RE: Yale Street Subdivision, Lots 2, 4, and 5

After meeting on site to look at the buildout of lots 2 and 5 of the Yale Street Subdivision, it was noticed that the buildout does not match the approved site plans. As discussed, the daylight basement features on lots 2 and 5 are not indicated on the site plan. As a result, the approved grading plans are not being constructed as proposed.

At this time, the City requests that you apply for a minor site plan amendment to the Yale Street Subdivision plan. In particular, this amendment should show new/proposed topography and a revision to sheet #9 (grading and drainage) is requested.

TITLE:
LOT 5
BUILDING LAYOUT
CWS ARCHITECTS

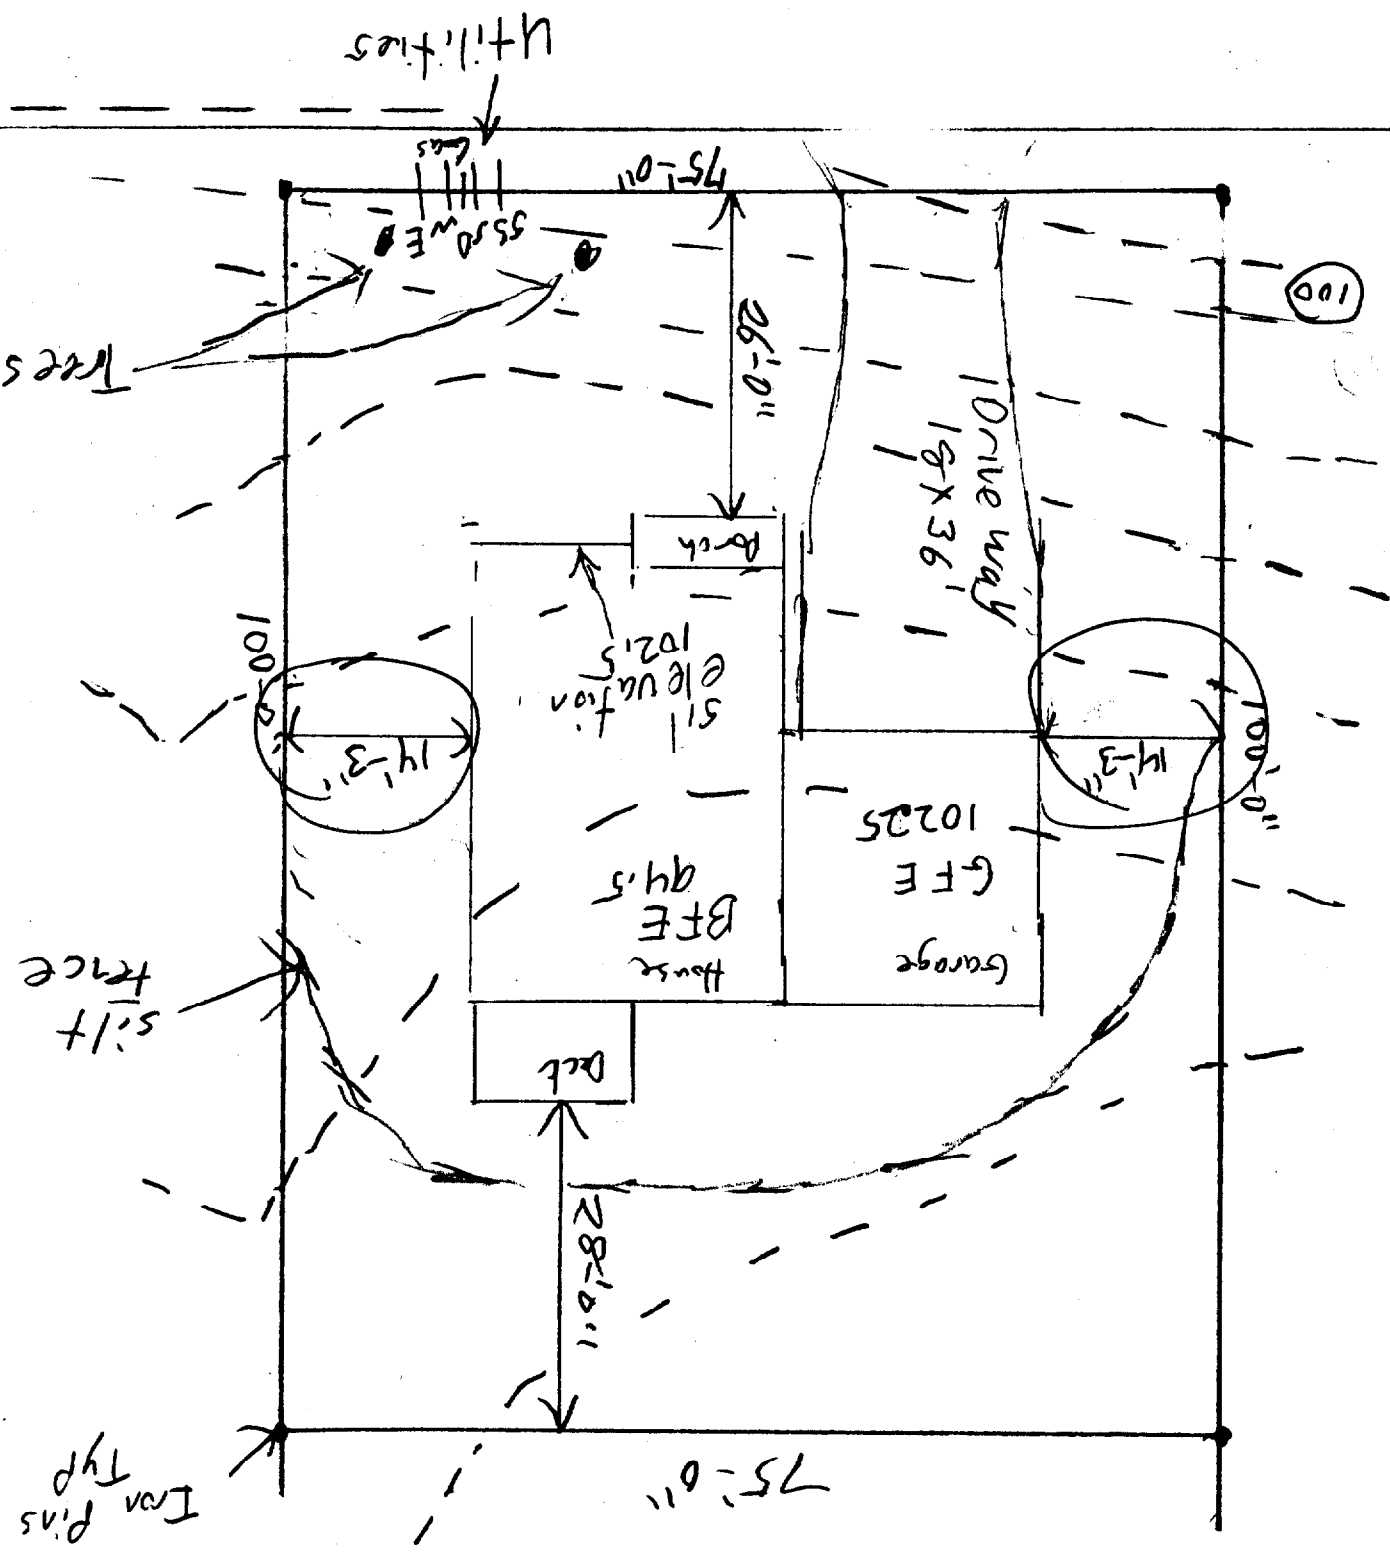
Currently lot 4's building permit application shows the same, building plans that do not match the grading/site plan. As I understand, you will be re-submitting to address this lot as well.
